Recommendation Report for Planning Permission for Works or Extension to a Dwelling

REF NO: AB/114/21/HH

LOCATION: 5 Pearson Road
Arundel
BN18 9HP

PROPOSAL: Erection of single storey rear extension and front porch extension following the demolition of existing front porch and detached rear shed/store

Title
**PLAN AND ELEVATIONS
AS PROPOSED**

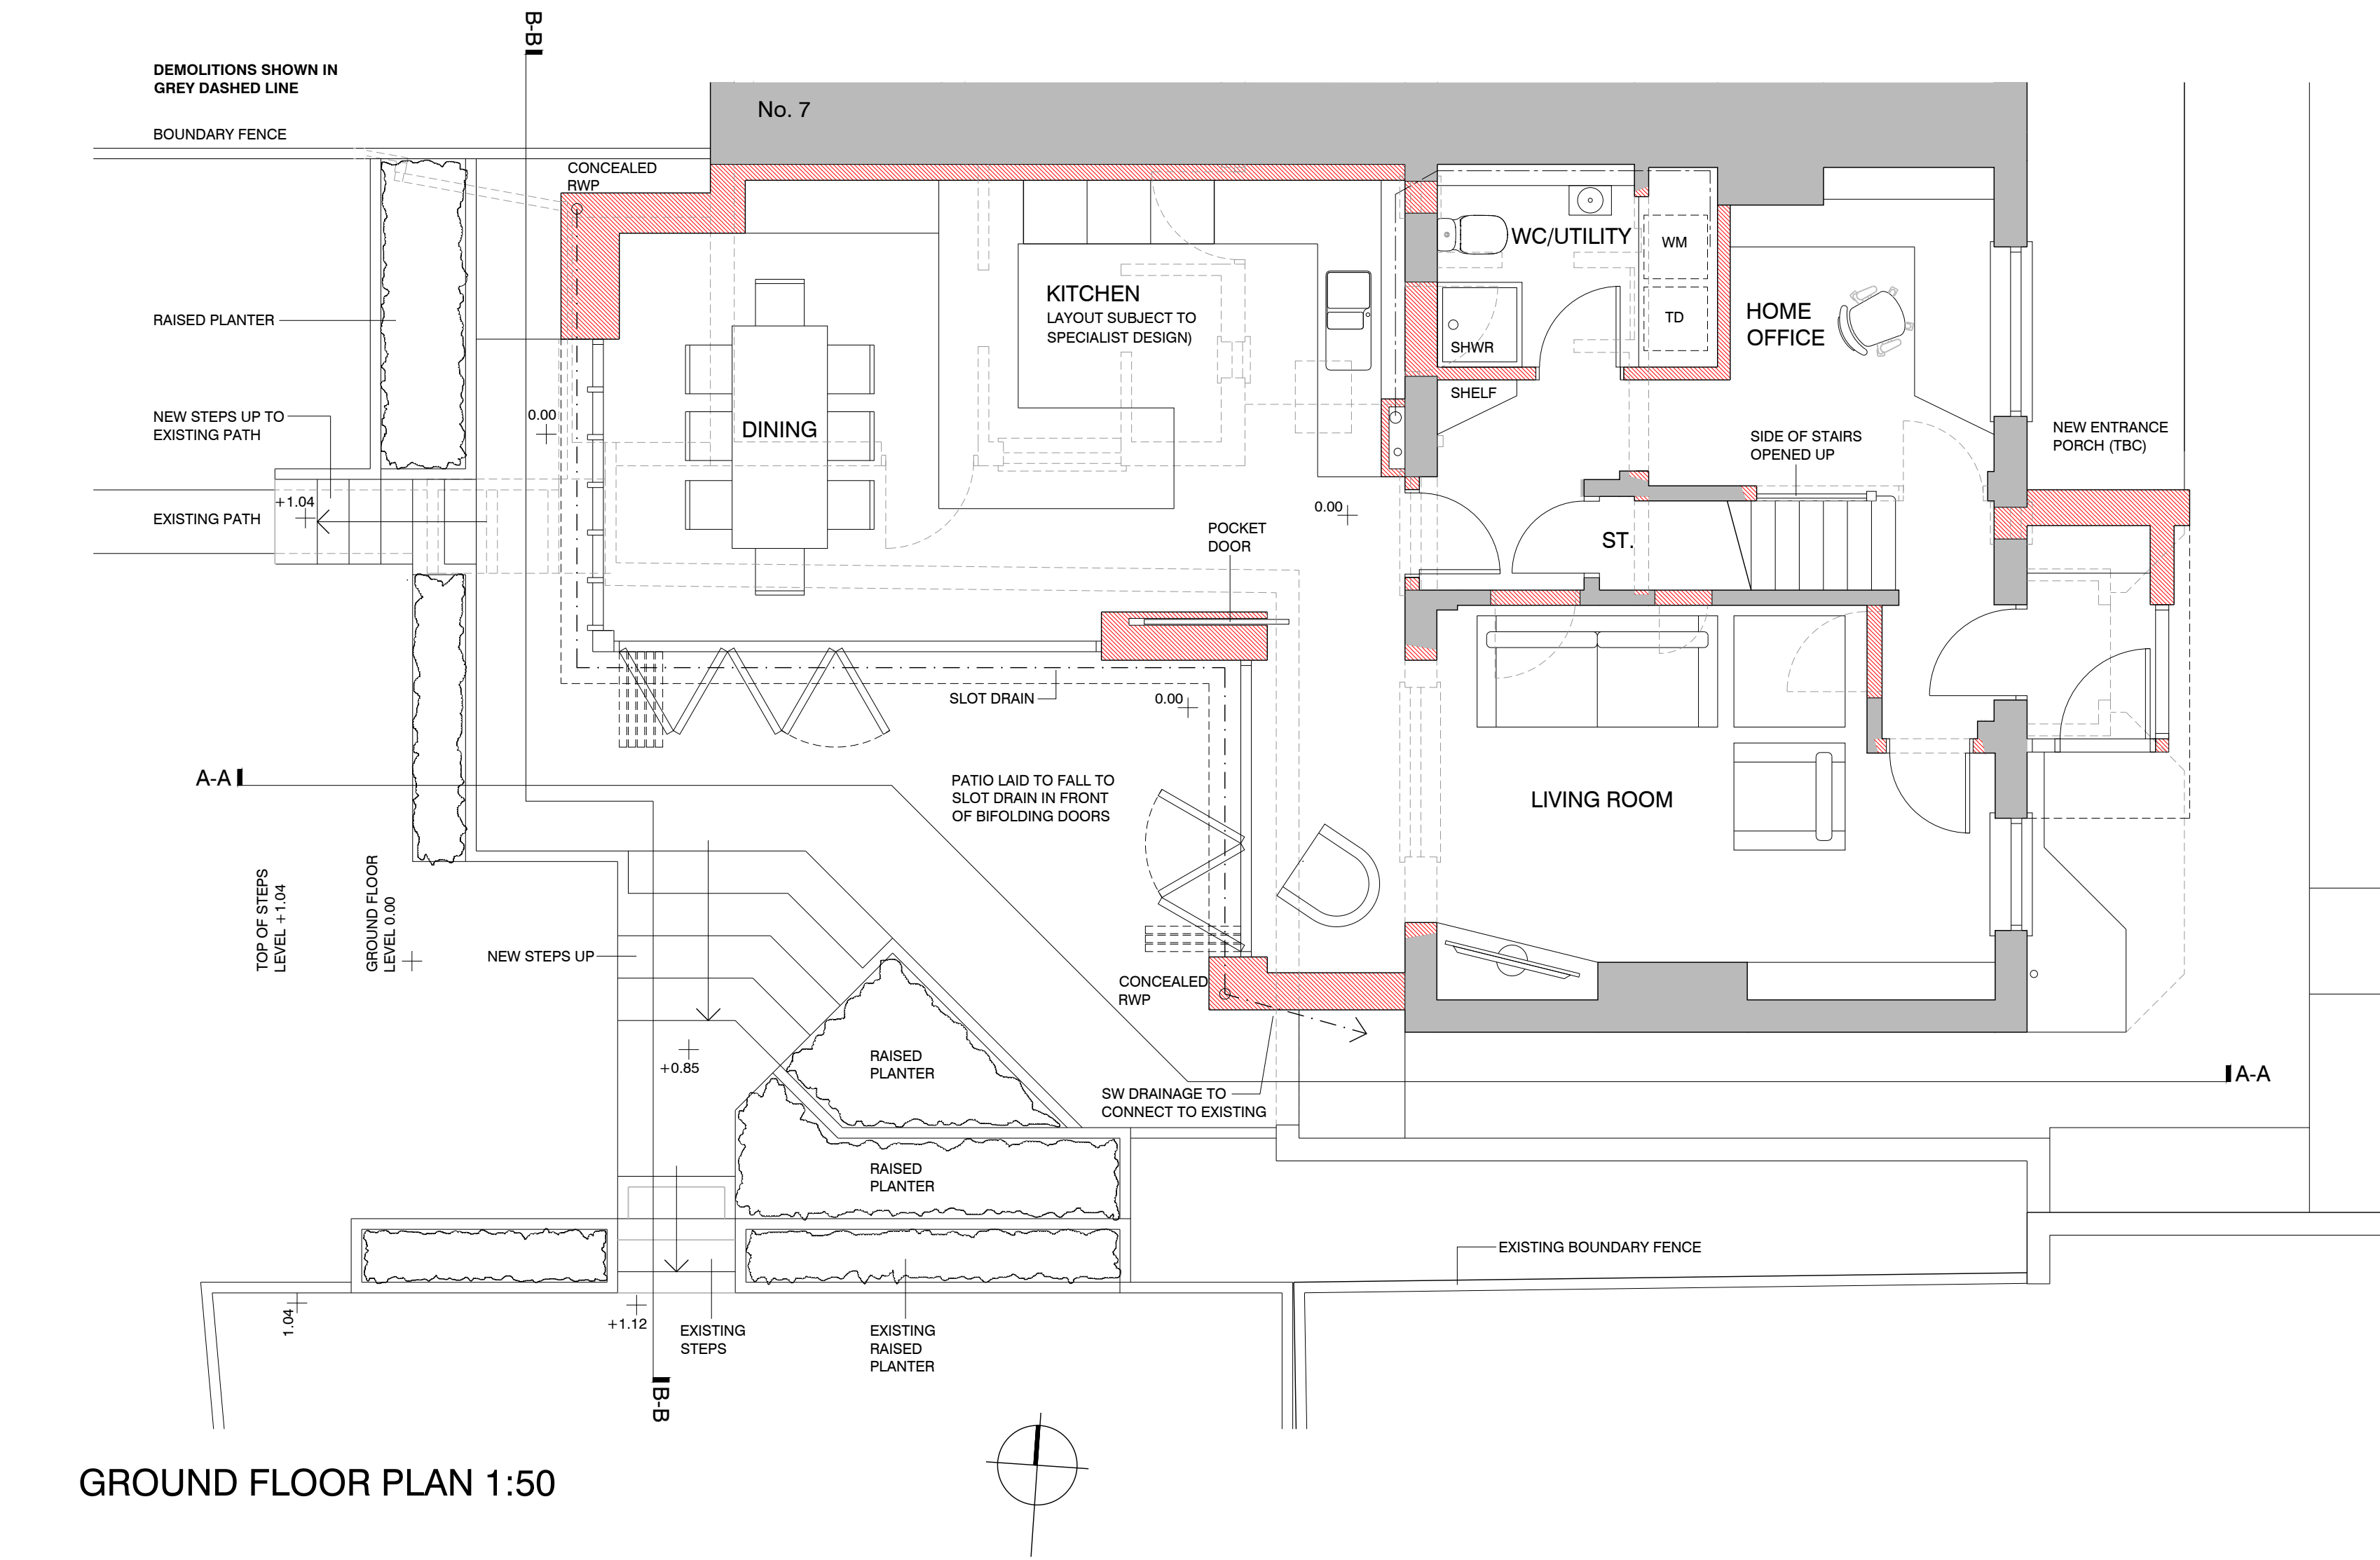
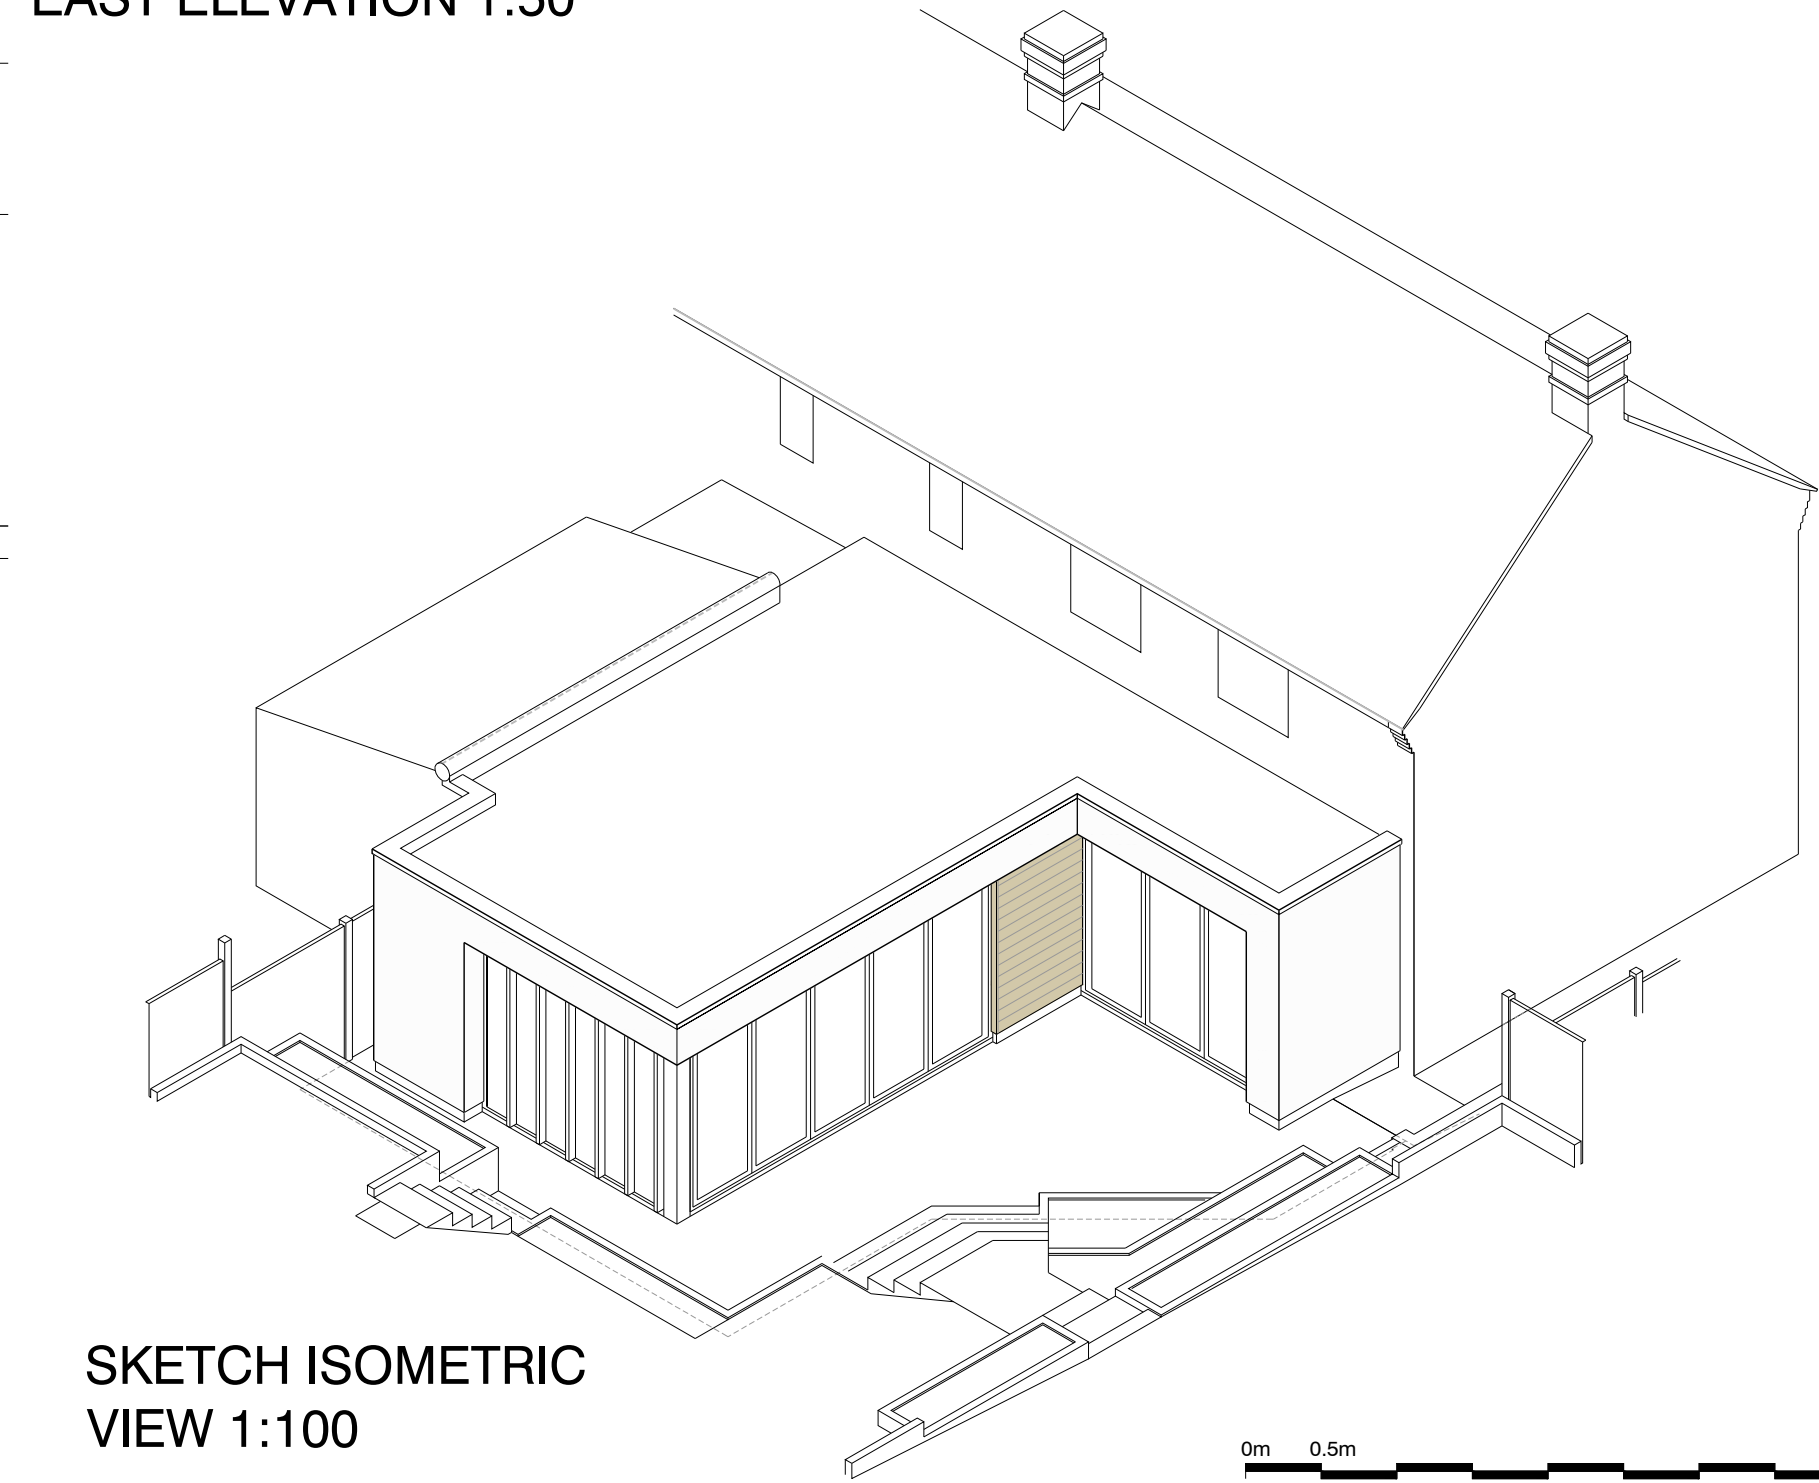
DESCRIPTION OF APPLICATION Demolition of existing single storey rear protrusion with a replacement extension to the rear measuring approximately 8m by 7.9m at its longest points. The structure would only be a maximum of 1.3m longer and 0.6m longer and wider than the existing structure being removed.

The rear extension will not be visible from the street and will not affect the street scene nor will it alter the spatial character of the area which consists of one and two storey properties with open frontages.

The amount of space to be created is considered appropriate when considered against the existing dwelling. It is noted that after the demolition the net increase in floor area is not large and will be an approximate increase of 25 m square.

The materials chosen for the build will be a departure to those currently found on site, however this is not seen as a reason to refuse this application as design guidance allows for greater design freedom with rear extensions not visible from the street.

The porch will be visible from the street, its styling will differ from the host dwelling; however, it will still retain similarities to other porches found in the area in that it will be flat roofed. The porch is considered subservient to the host dwelling as it is significantly smaller in scale.

The rear extension accords with the 45-degree rule for rear extensions. The additional length of the extension of 1.4m past the end of the existing extension, which sits on the boundary adjoining a mirrored structure at no.7, has been moved away from the shared boundary by 300mm. Its overall height will be lower than the ridge height of the existing structure being demolished, It is not considered to be overbearing or overshadow neighbouring properties.

In terms of overlooking, all proposed fenestration will be at ground floor level where it is generally accepted that there are no negative impacts from overlooking.
